**Subject: Mark Armijo Academy Neighborhood Impact Assessment  
NM 45 and Gonzales Rd SW  
Albuquerque, New Mexico**

This letter is to inform you that the FINAL Mark Armijo Academy Neighborhood Impact Assessment (NIA) on the southwest quadrant of NM 45 and Gonzales Rd SW dated April 2025 has been reviewed. See Exhibit A for the site plan for this development.

Figure 1: Site Plan

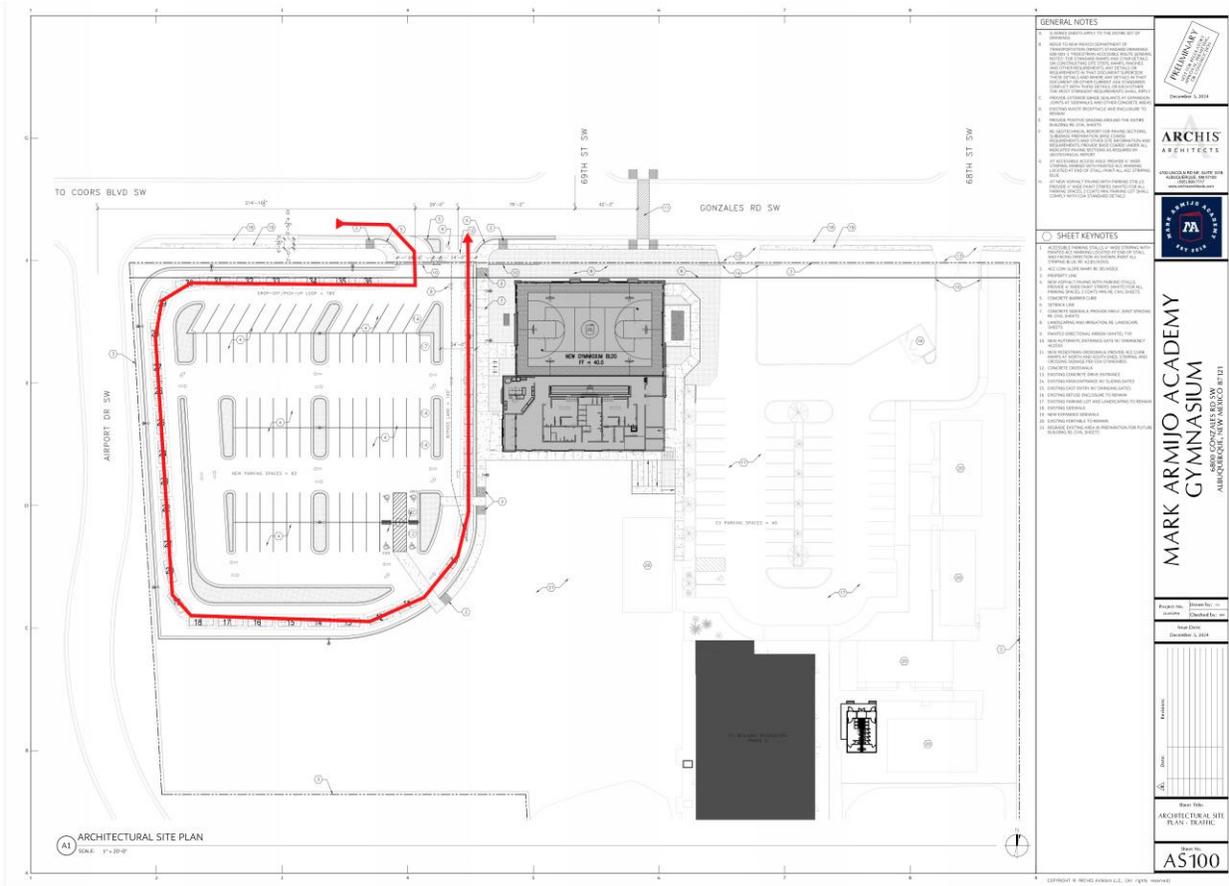
The NMDOT has no objection to using the existing unsignalized access on NM 45 and Gonzales Rd. The recommendations provided for these analyses are shown in Exhibit B attached. Based on these analyses, the following conditions are required:

1. At NM 45 and Gonzales Rd the development
  - a. Shall install a median to limit the access to right-in, right-out, and left-in only. NMDOT is open to the consideration of a roundabout in lieu of the modified access;
  - b. Shall extend the existing southbound left deceleration lane at a length of 370-feet plus 25-foot queue, to a total length of 395-feet including taper; and
  - c. Shall install a northbound right lane at a length of 370-feet including taper.
2. The NMDOT shall provide final approval on the design for the offsite improvements. The developer shall agree to incorporate all the comments requested by the NMDOT.
3. The NMDOT shall require a preconstruction meeting once plans are finalized, prior to any construction activities.
